Amongst other data, it contains splays, showing the visibility drivers would have from proposed drives off Lingards Road.

The thick yellow line is the splay for plot 37, looking north easterly, down Lingards Road.

Project	Housing at Lingards Road, Slaithwaite	William Best RIBA
Client	S B Homes Ltd	The Chapel House
Drawing	SITE SECTIONS H, J, K	22 Pole Gate
Scale	1:200	Scammonden
Dwg No	2019 572 55	West Yorkshire
Rev	B	HD33FW
		Tel 01484 845896

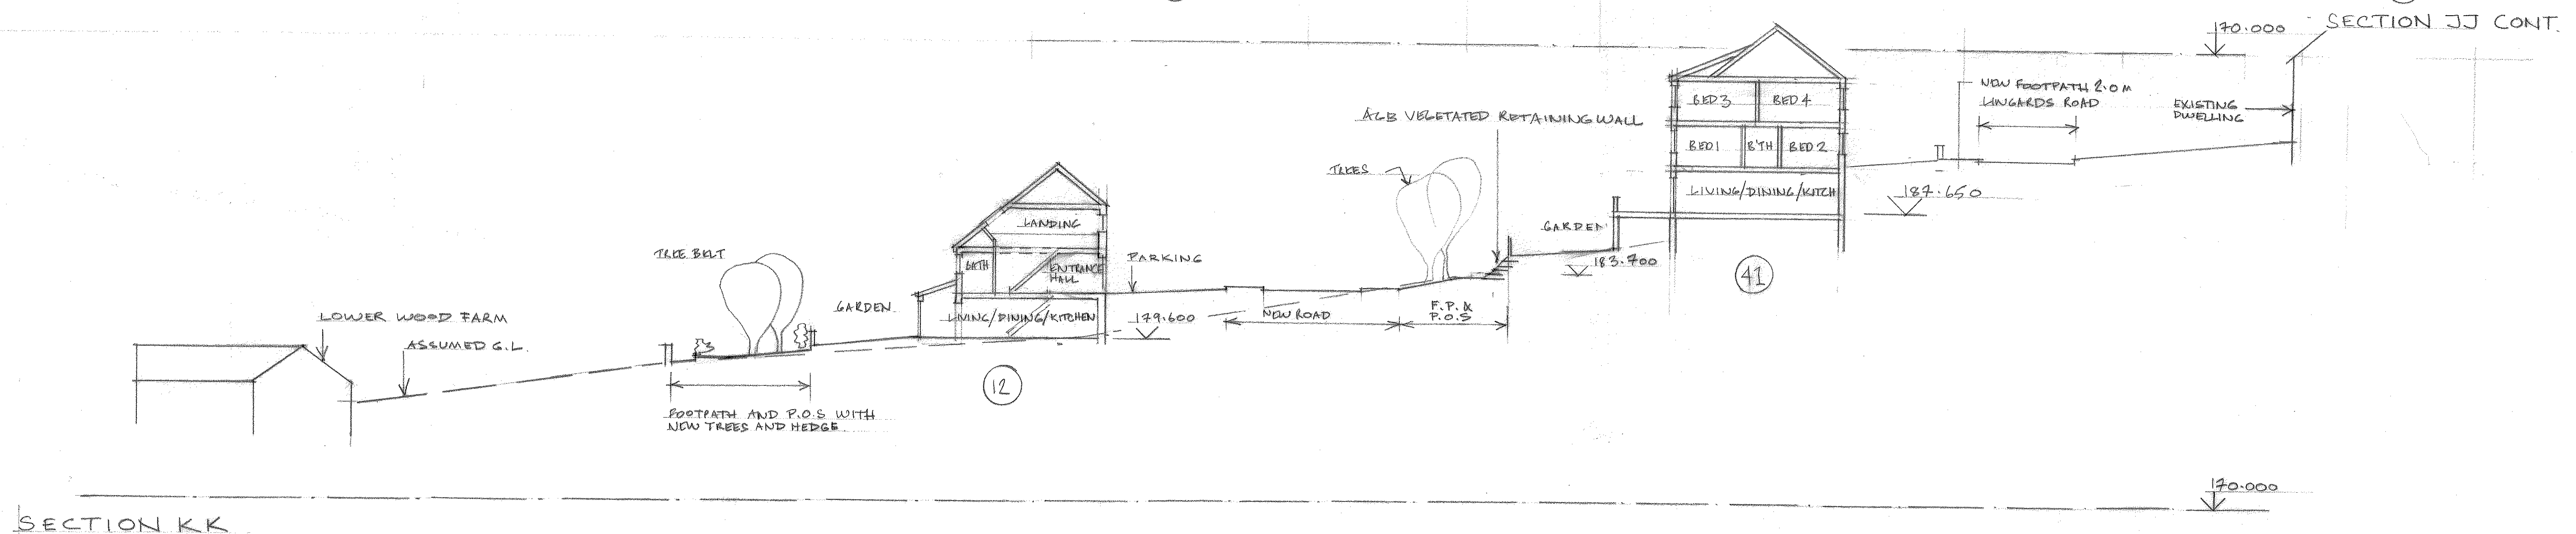
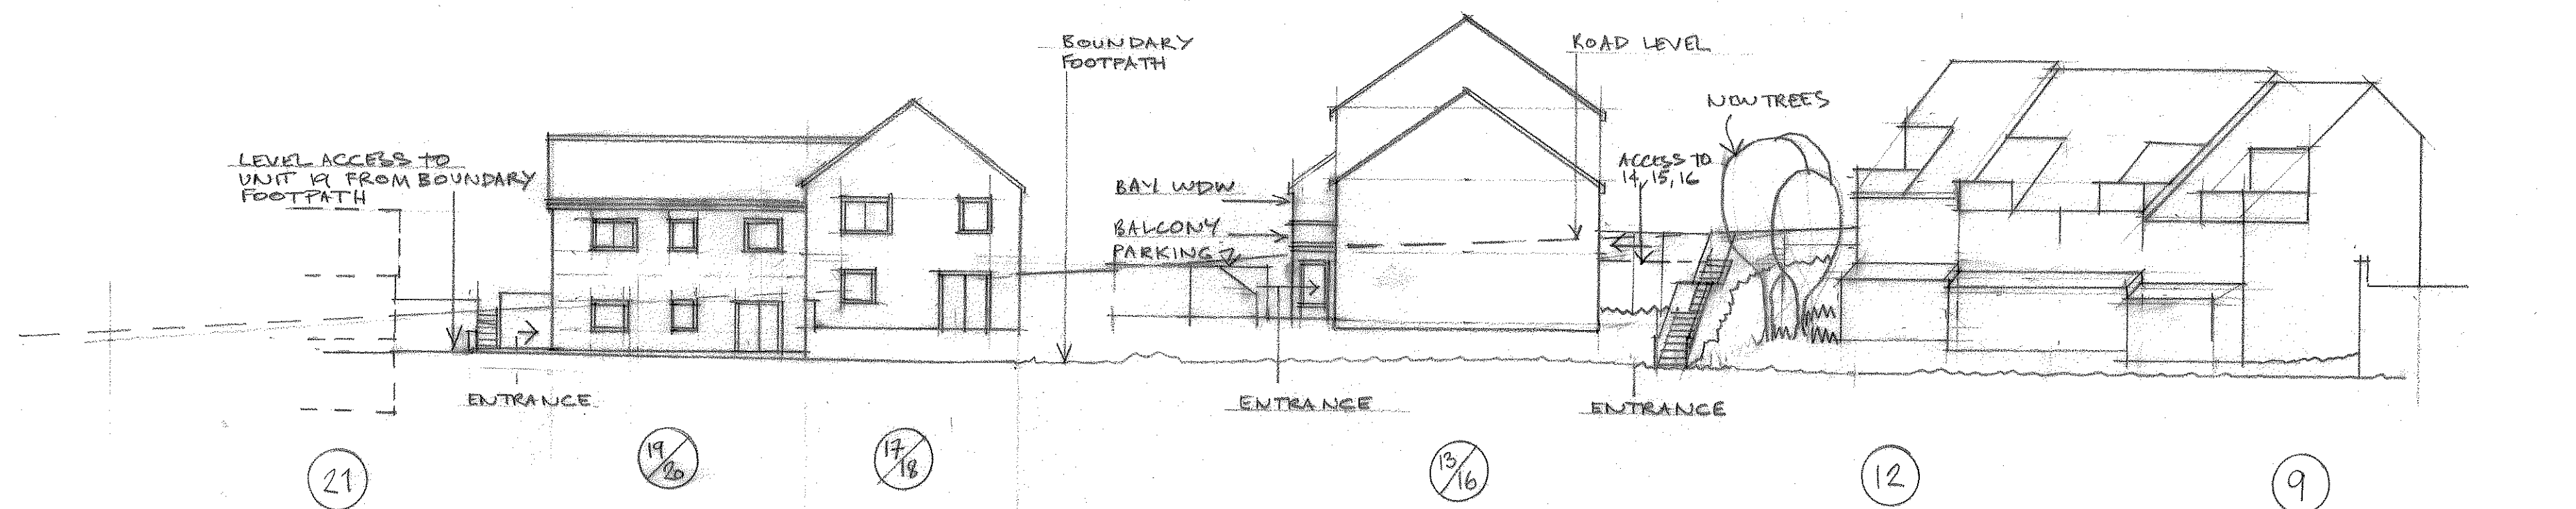
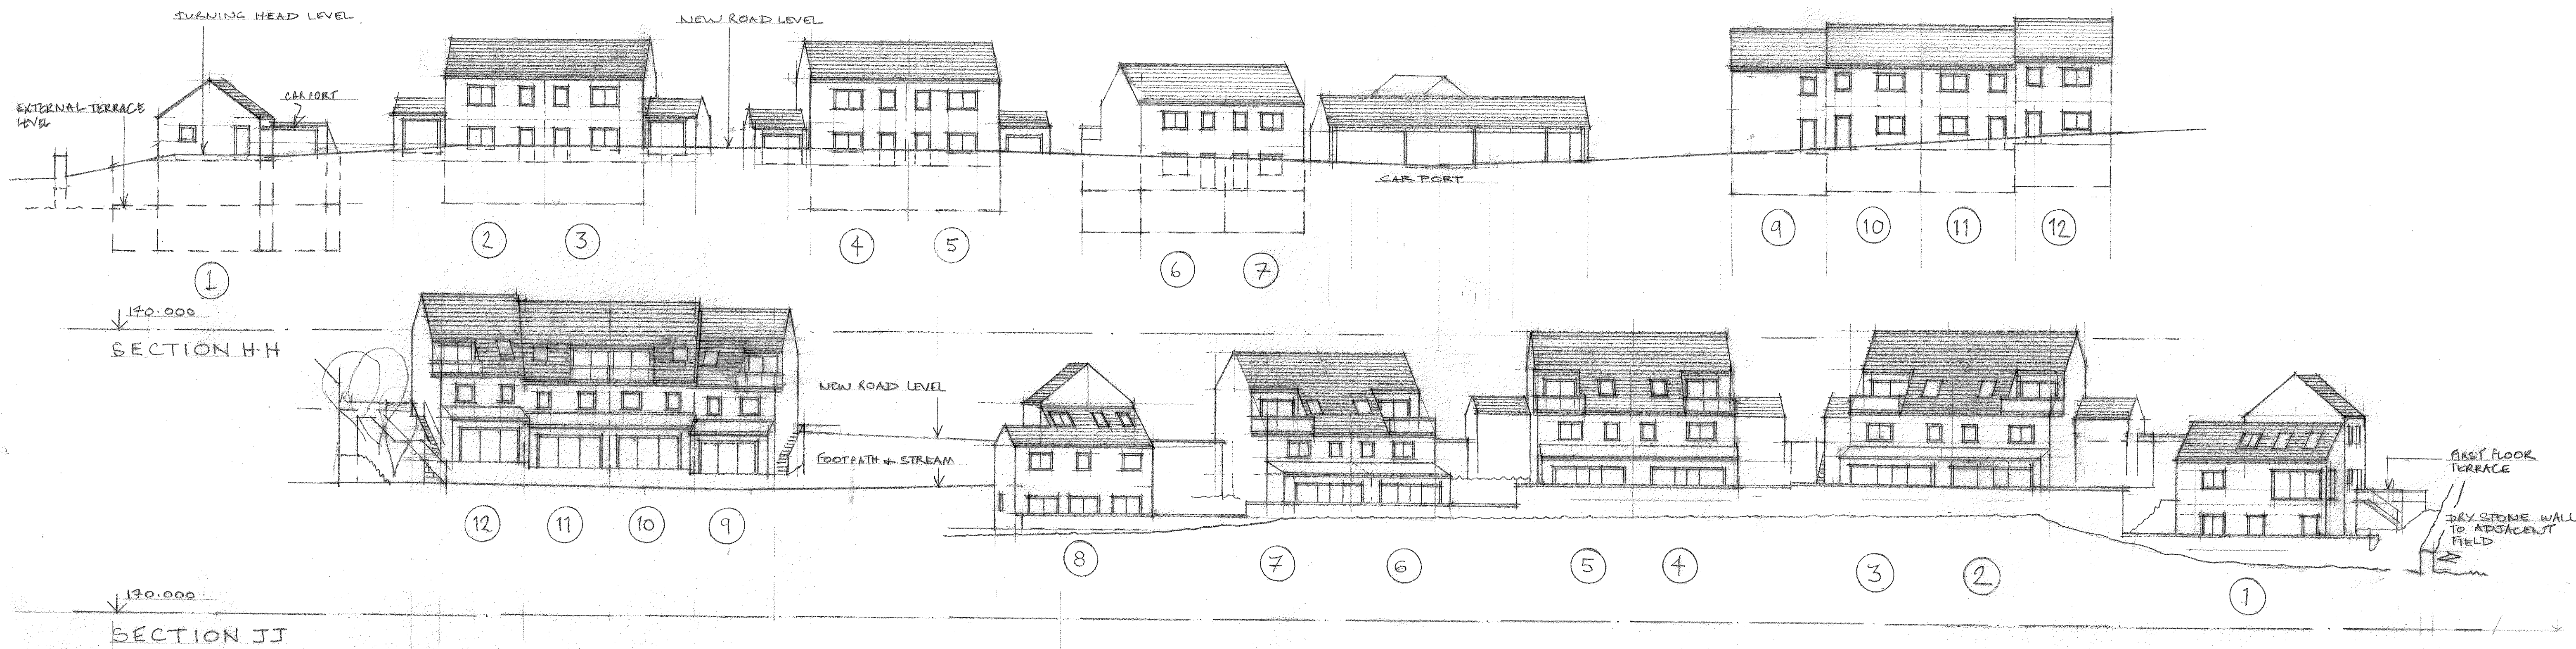
The veracity and viability of these splays has to be seriously questioned, due to the brow of the hill.

Over half of these splays cover an area that would be out of sight, to any drivers using these respective drives.

Concerning plot 38, only 19 metres, of the required 43m, could provide visibility.

If you look at the same splay for plot 37 (although others suffer similarly), which is the yellow line mentioned above, you will see that 16.39m of it is shown passing through the stone wall that fronts the proposed dwelling.

The splays also have to be questioned in relation to the wheelie bins planned to be positioned at the end of the drive.

As has been commented elsewhere, only one SMALL wheelie bin is allowed for on the plan, but two STANDARD sized wheelie bins are required.

Placing two wheelie bins, where planned, would, in my estimation, reduce driver visibility even further.
